Development Management
Lincolnshire County Council
County Offices
Newland
Lincoln LN1 1YL
Tel: 01522 782070
developmentmanagement@lincolnshire.gov.uk

To: South Holland District Council Application Ref: H14-1219-25

Proposal: **Change of use to 2 separate dwellings**

Location: **Sense, 38 Church Street, Pinchbeck, Spalding, PE11 3UB**

| Client: MR. & MRS. P. FOX | Proposal: CHANGE OF USE TO TWO DWELLINGS AT 38 CHURCH STREET, PINCHBECK | Scale @ A3 1 : 250 | Title BLOCK PLAN - PARKING |

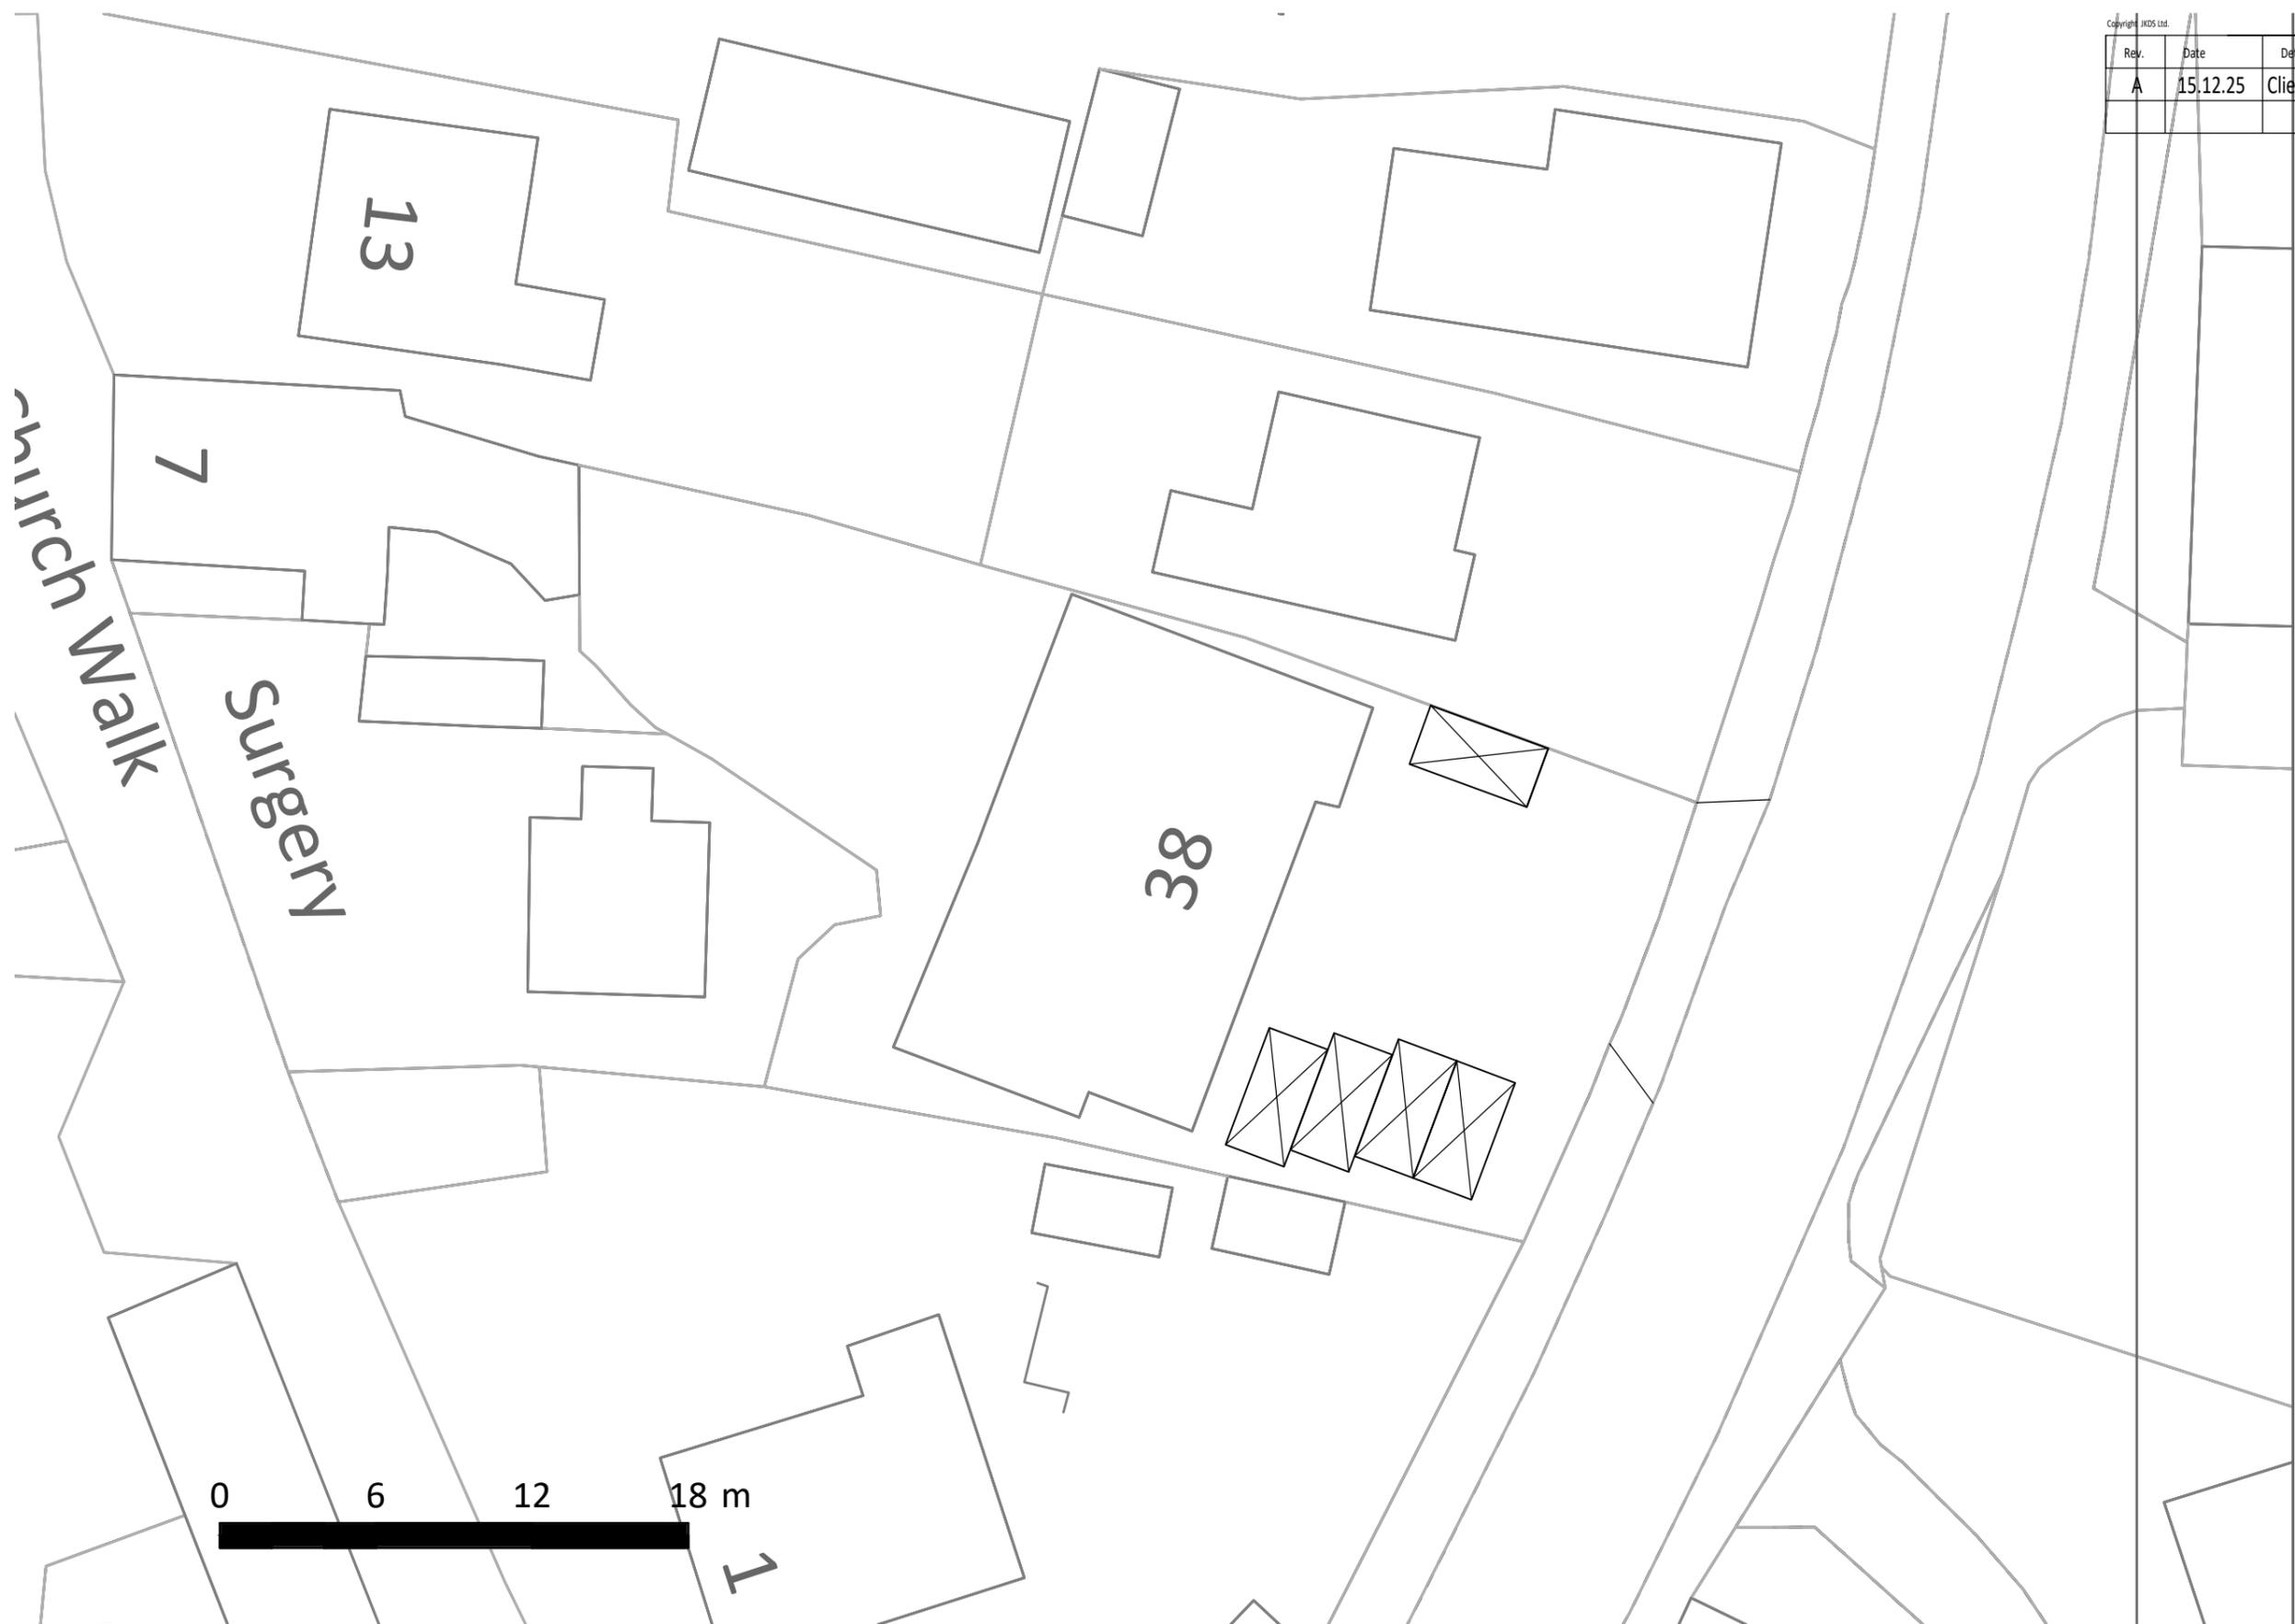
Please can you ask the applicant to confirm if the same access is being used for both dwellings and to detail the parking and turning on the block plan to show vehicles can leave in a forward gear. For the 3 bed house two parking spaces should be provided and for the 4 bed house three parking spaces should be provided.
